DECISION DELEGATED TO HEAD OF PLANNING

Application No:	H05-1112-25	Applicant:	Mr C Moss
Proposal:	Proposed extension		
Location:	Cream House Church End Fleet		
Terminal Date:	10th July 2026

This is a householder application seeking permission for a proposed extension at Cream House, Church End, Fleet.

ELEVATIONS AS PROPOSED

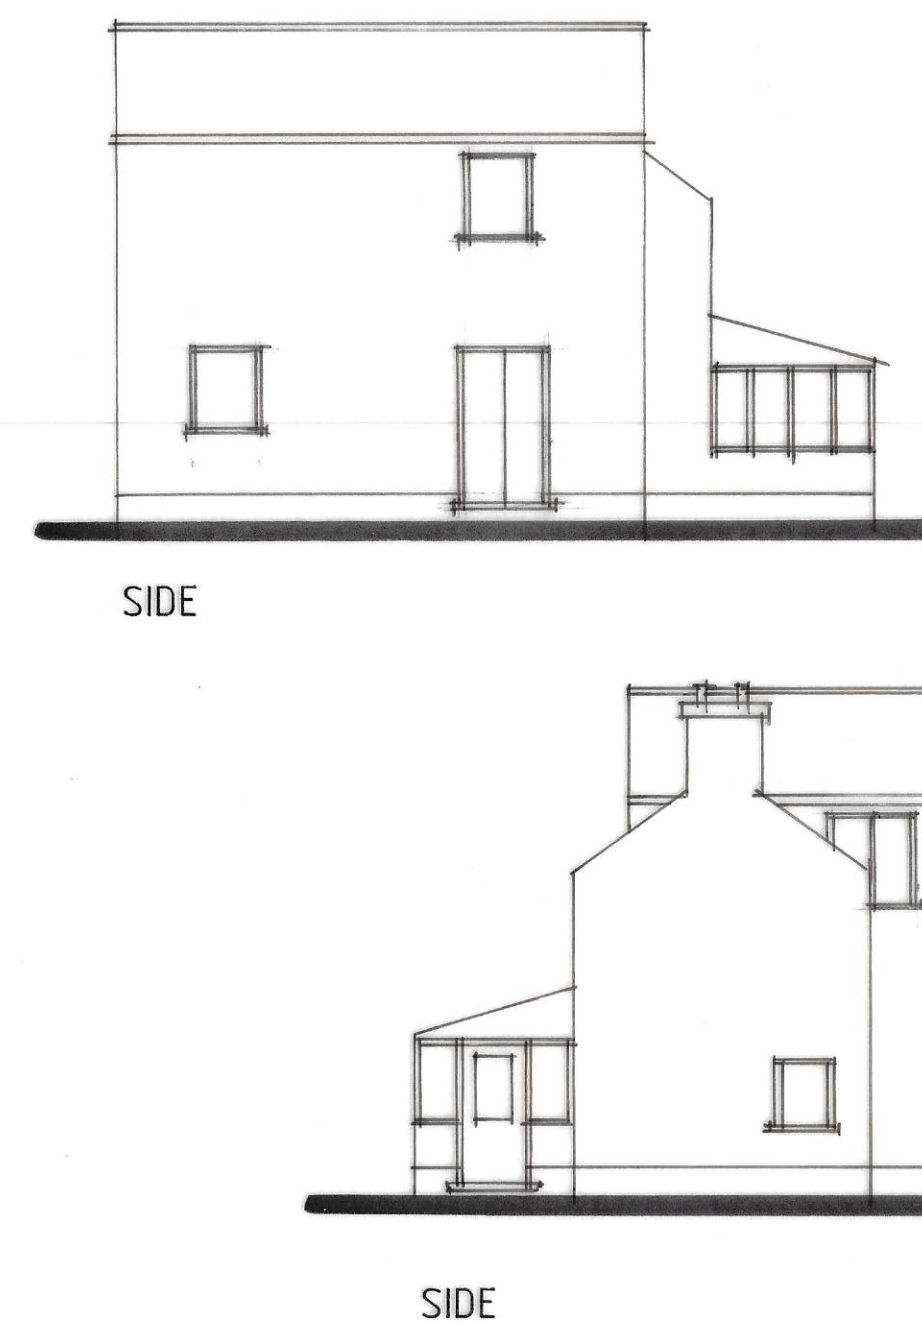
It should be noted that the proposal has had various correspondence and amendments in order to reach a suitable design with the previous scheme proposing an extension which would have protruded from the side elevation by roughly 5500mm and would have a length of around 6700mm. Further to this, the overall height of the extension was to sit at 6500mm to the ridge and 5000mm to the eaves.

The main concerns raised by the LPA were regarding the height of the extension sitting higher than the existing dwelling. As this has been significantly reduced to a single storey level this is now considered to be acceptable and comprises a proportionate scheme which can be approved.

ELEVATIONS AS PROPOSED

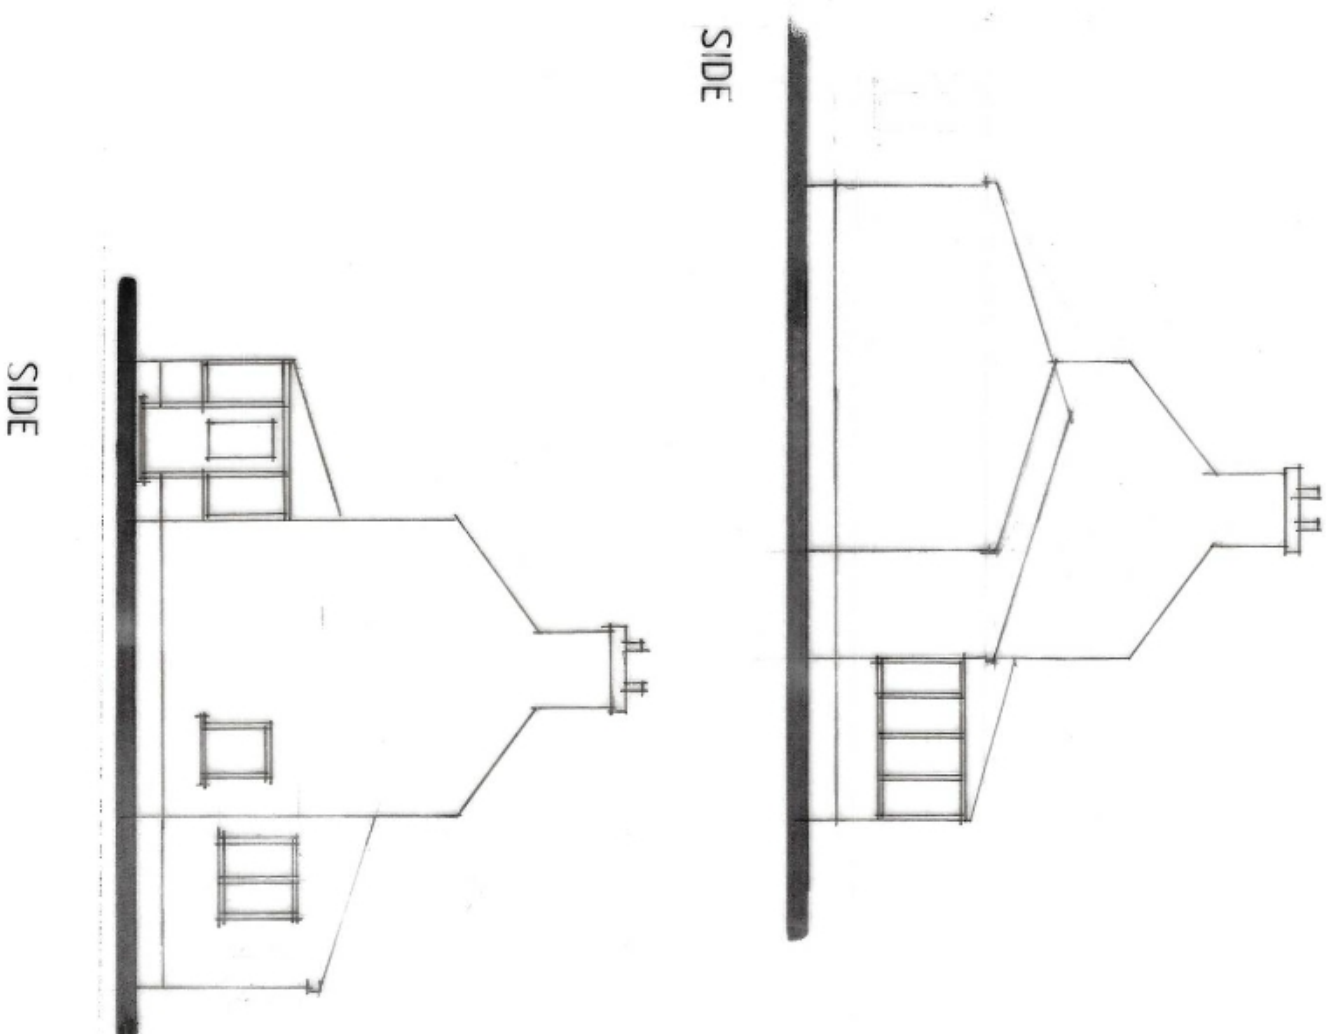
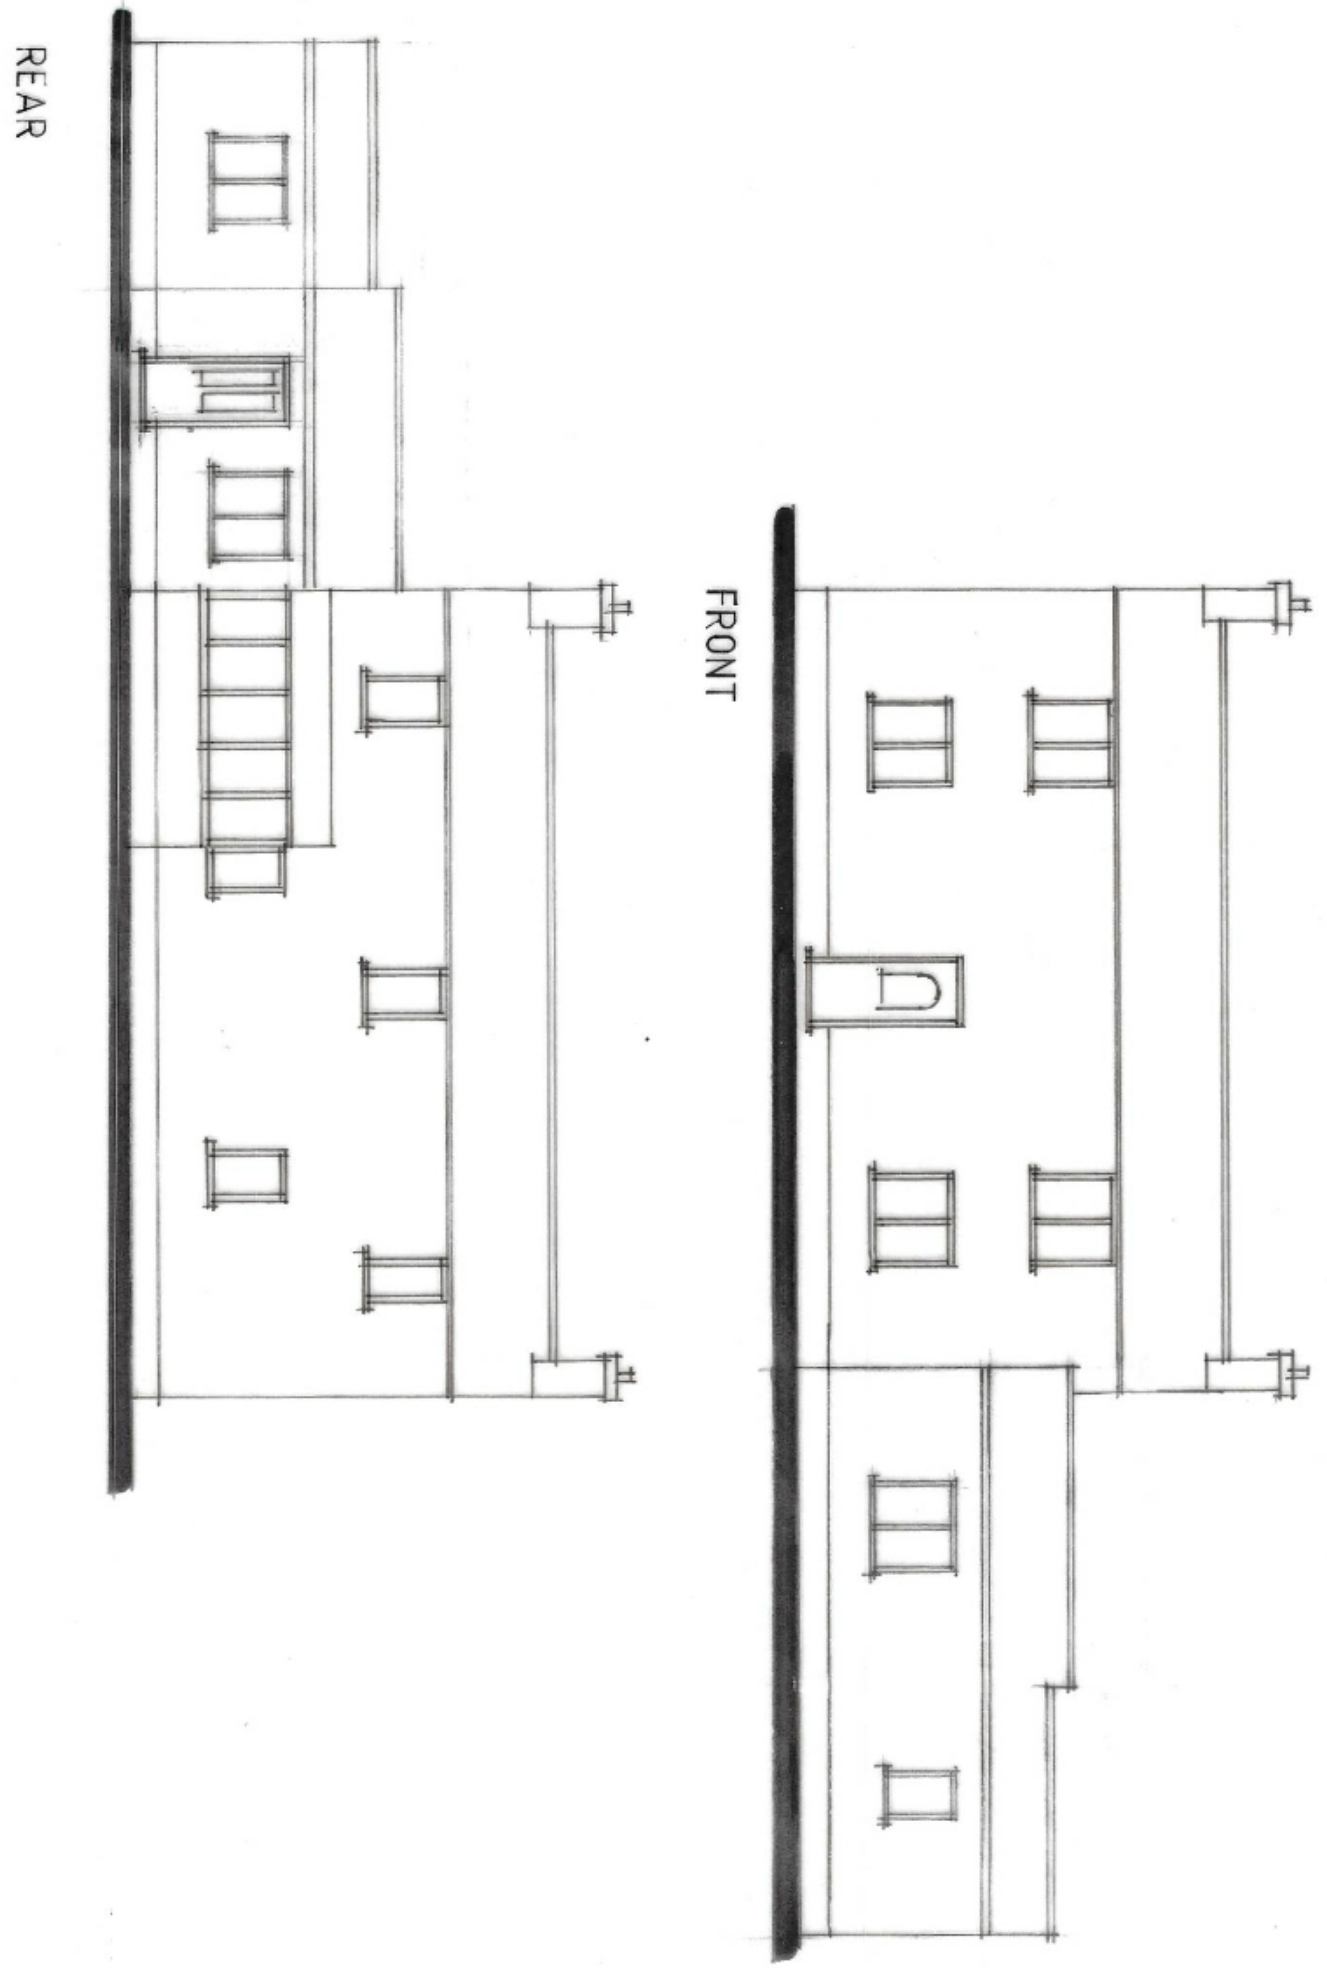
As outlined above, the extension would protrude from the side elevation by around 7200mm and would have a total width of roughly 6200mm. Further to this, the height of the extension is staggered and drops from 3600mm to 3300mm. It is therefore considered that the height of the extension makes it appear subordinate in relation to the host property and is an evident extension in this regard.

Notwithstanding this, the proportions of the extension must be assessed in order to ascertain whether the bulk is considered to be acceptable. The existing dwelling has a current width of 10600mm and therefore the proposal seeks to increase the dwelling by over half the width of the existing dwelling house. Whilst this may be typically resisted elsewhere, it is considered that the dwelling has ample room within its plot to support such an extension and the staggered nature throughout helps reduce the overall extent of built form. As such, this is considered to be acceptable.
